SITE MAP

CANTERBURY
DEVELOPMENT

Site Plan_v1-redline.pdf Markup Summary

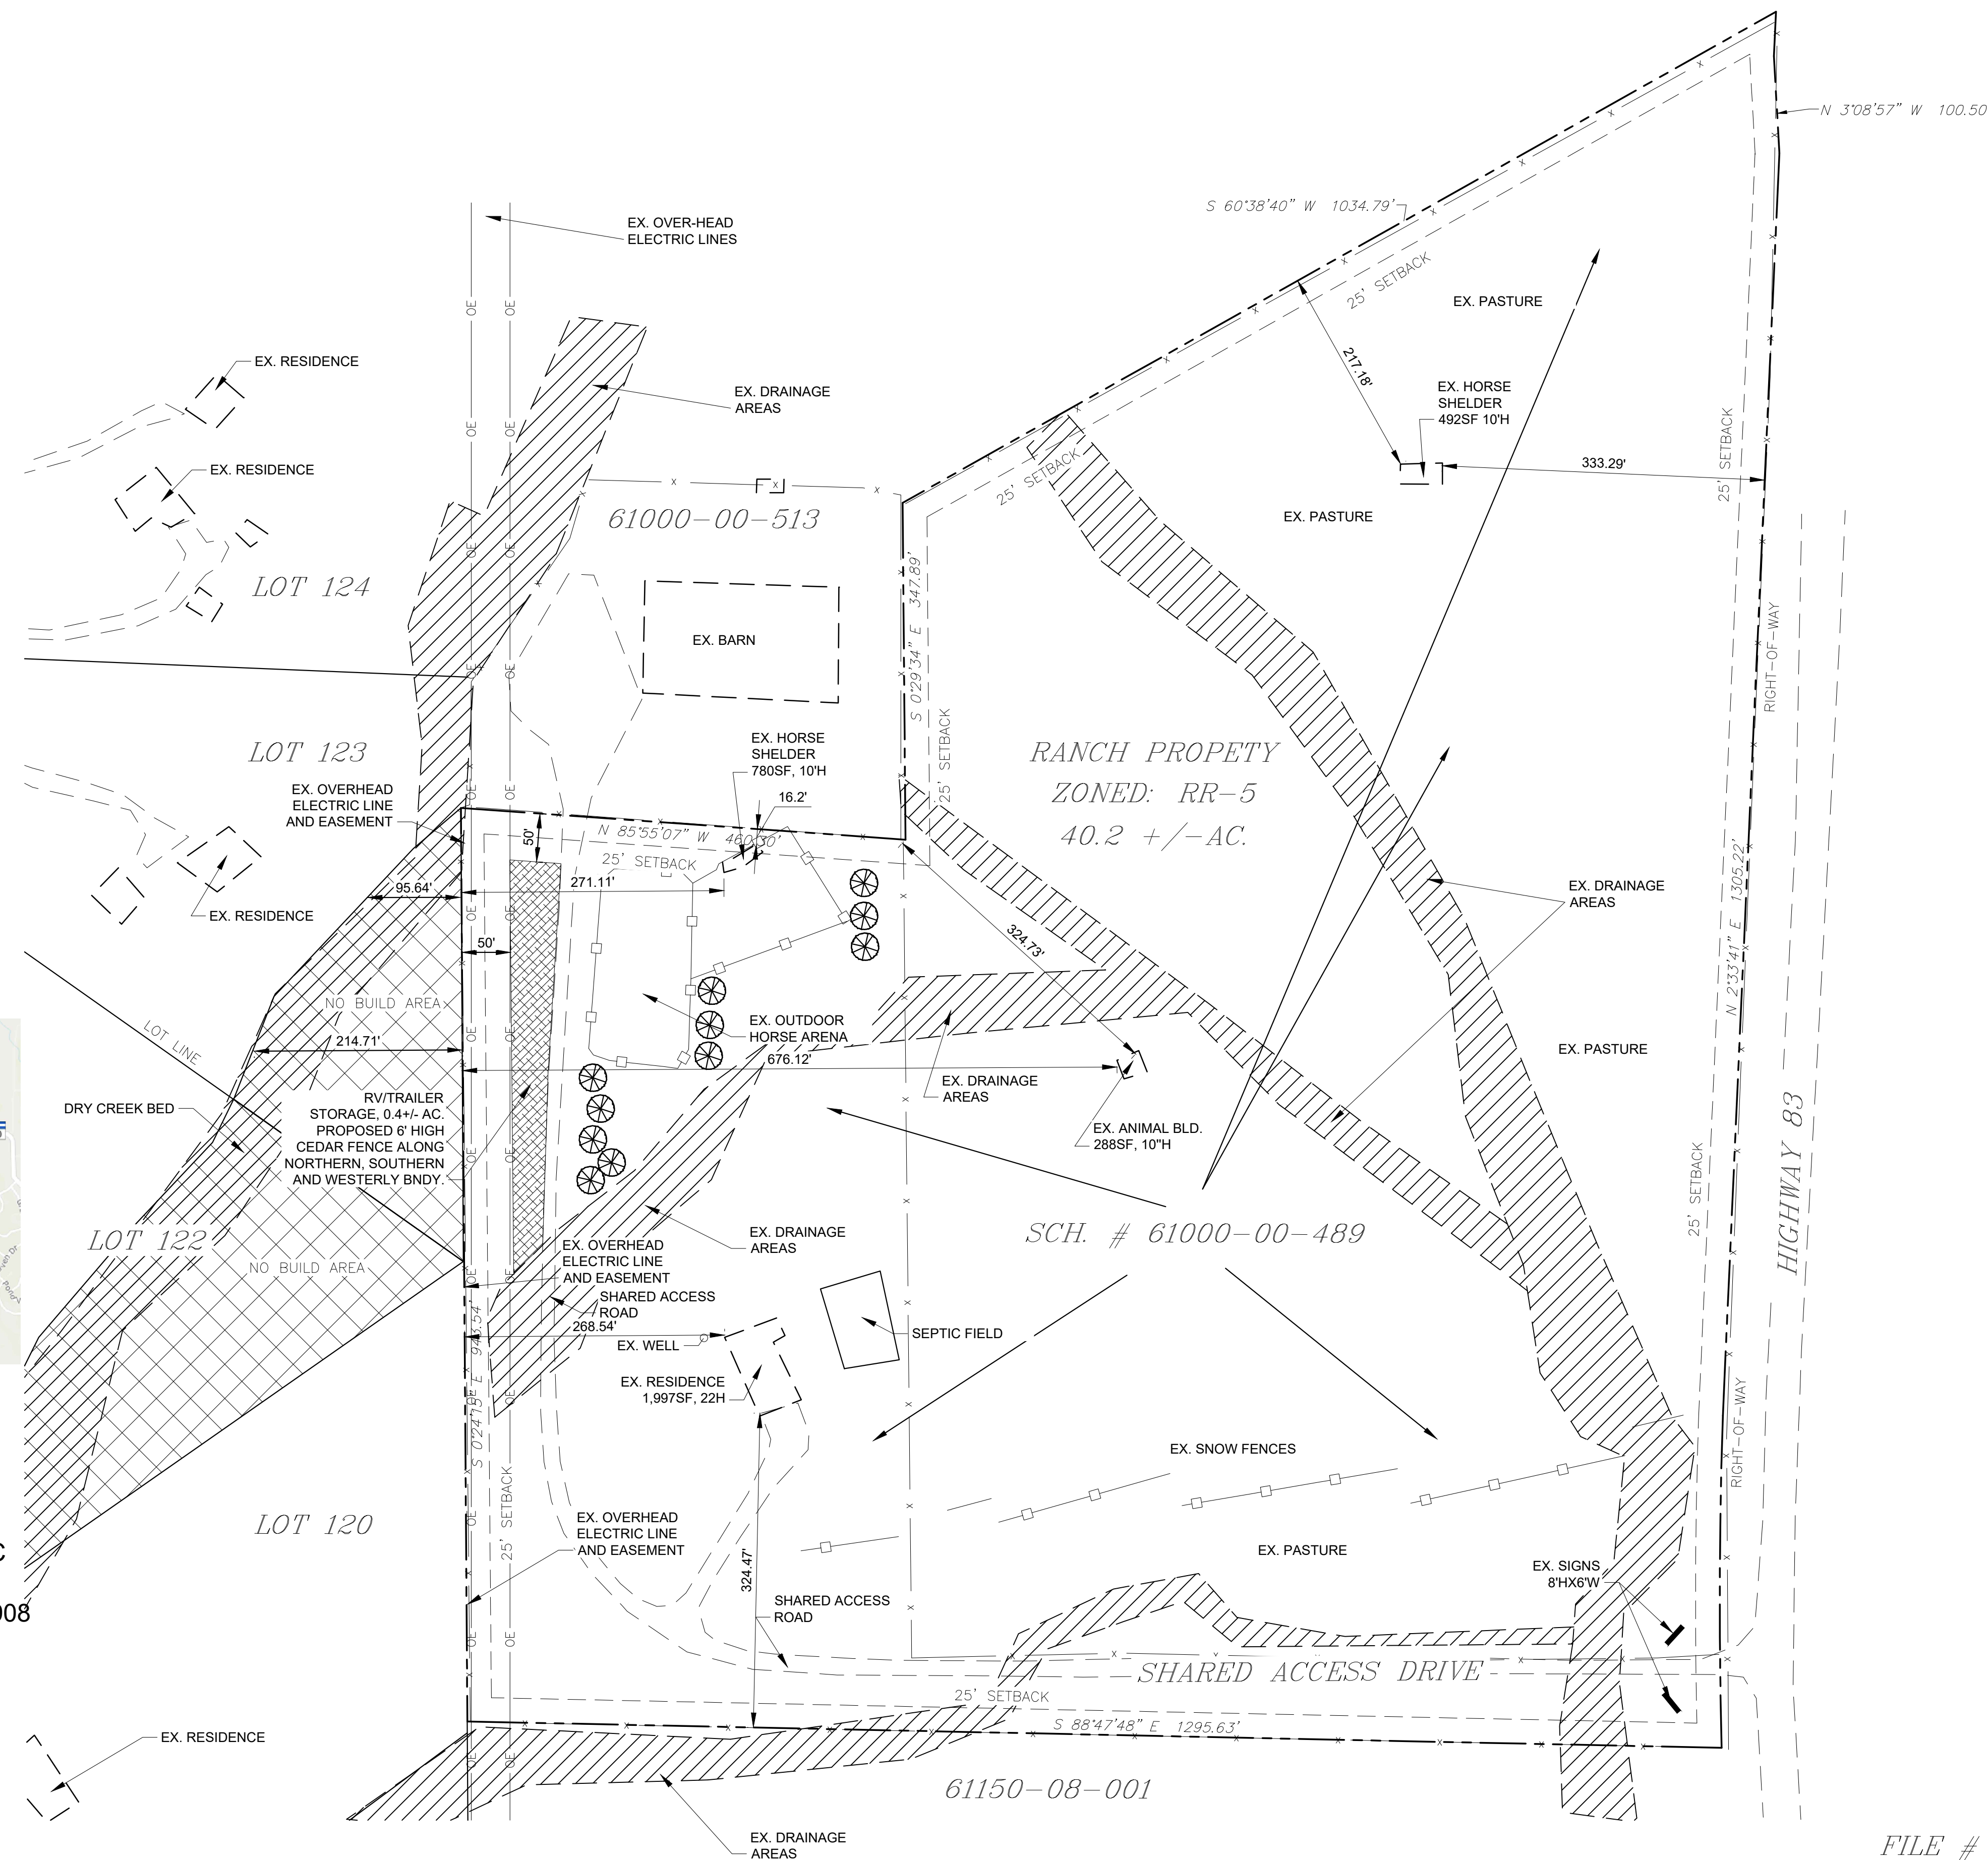
Show an accurate depiction of the parcel shape in the site plan drawing and setbacks from all existing structures.

Show easements

Show setbacks from outside storage of RV's and indicate whether or not a Board of Adjustment Hearing will be applied for or the 50 foot setback met.

Show the screening that is required.

This barn does not look like it is on the subject property
